From: marianne leslie
To: [Robin Proebsting](#)
Cc: [Marianne Leslie](#)
Subject: File No. SUB19-002, B&G Club proposed development
Date: Wednesday, May 8, 2019 4:32:00 PM

PRELIMINARY TREE RETENTION AND REPLACEMENT PLAN
2825 W MERCER WAY
PRELIMINARY PLAT
 PARCEL #2174502425
 CITY OF MERCER ISLAND WASHINGTON

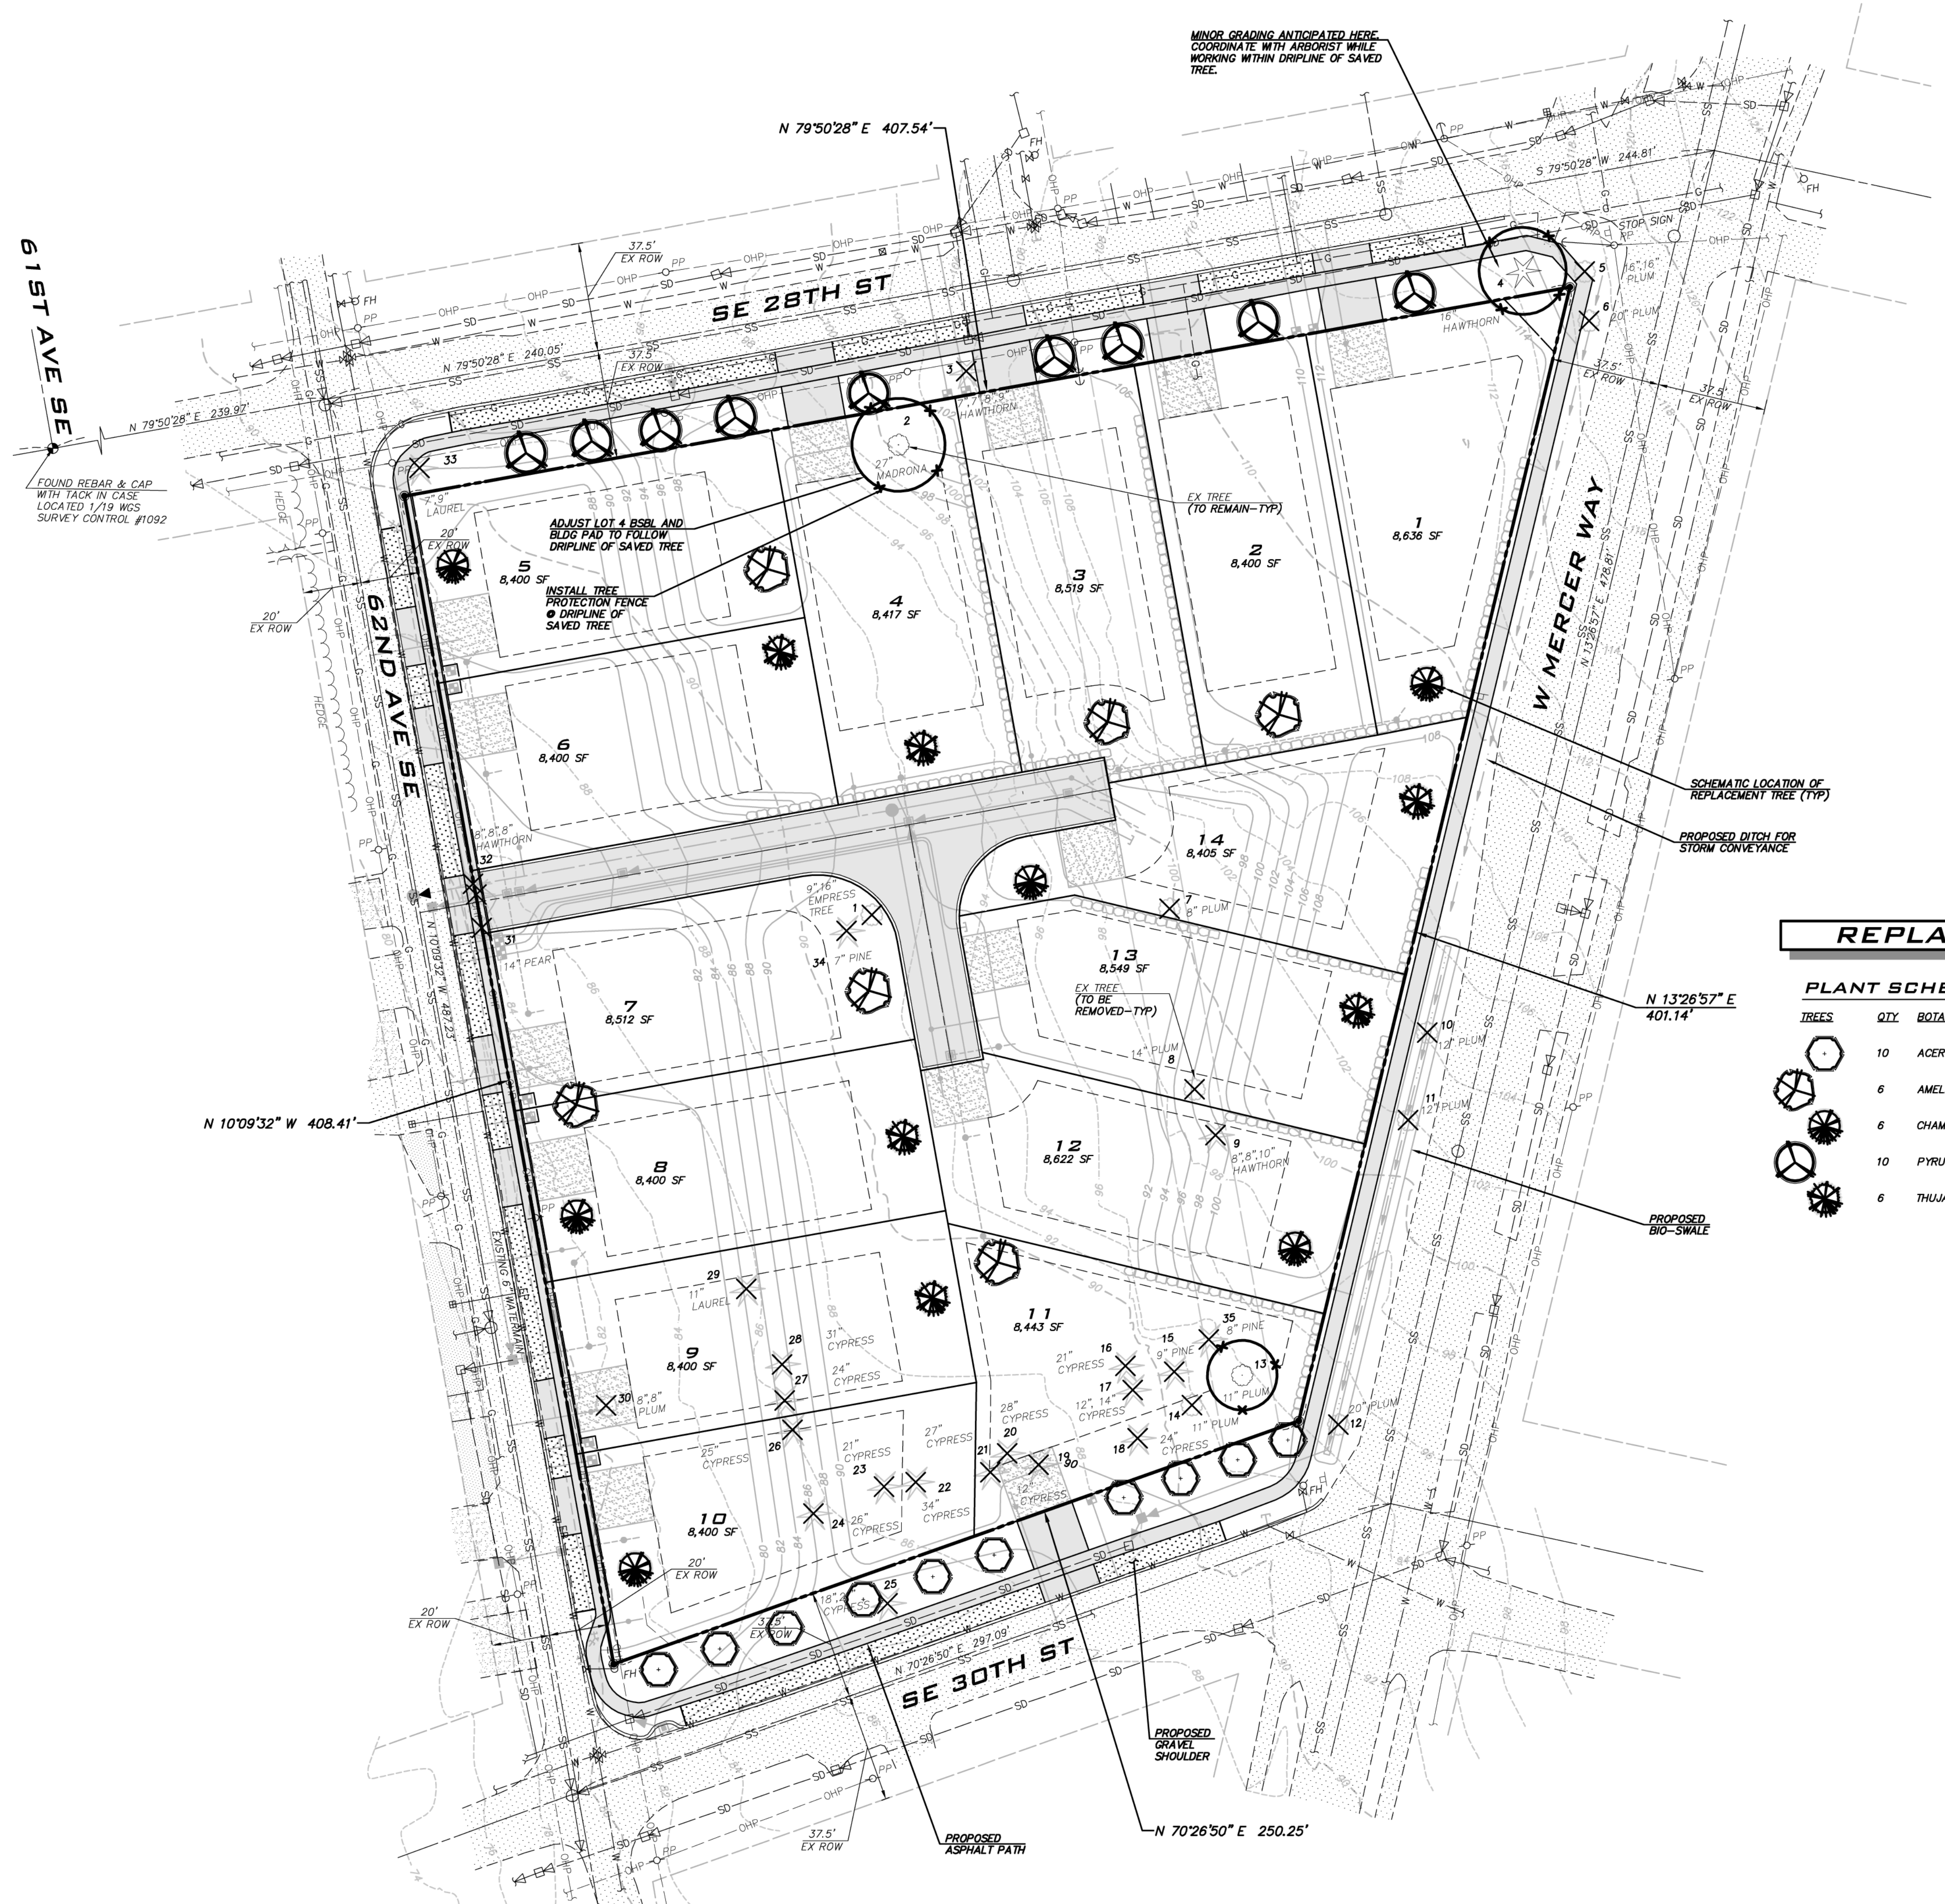
4. With the removal of current trees to make way for construction, will there be a height limitation on the newly planted trees so surrounding properties can maintain their current views? There are an abundance of trees that are "dwarf" in size which could be used without negatively affecting current view corridors.
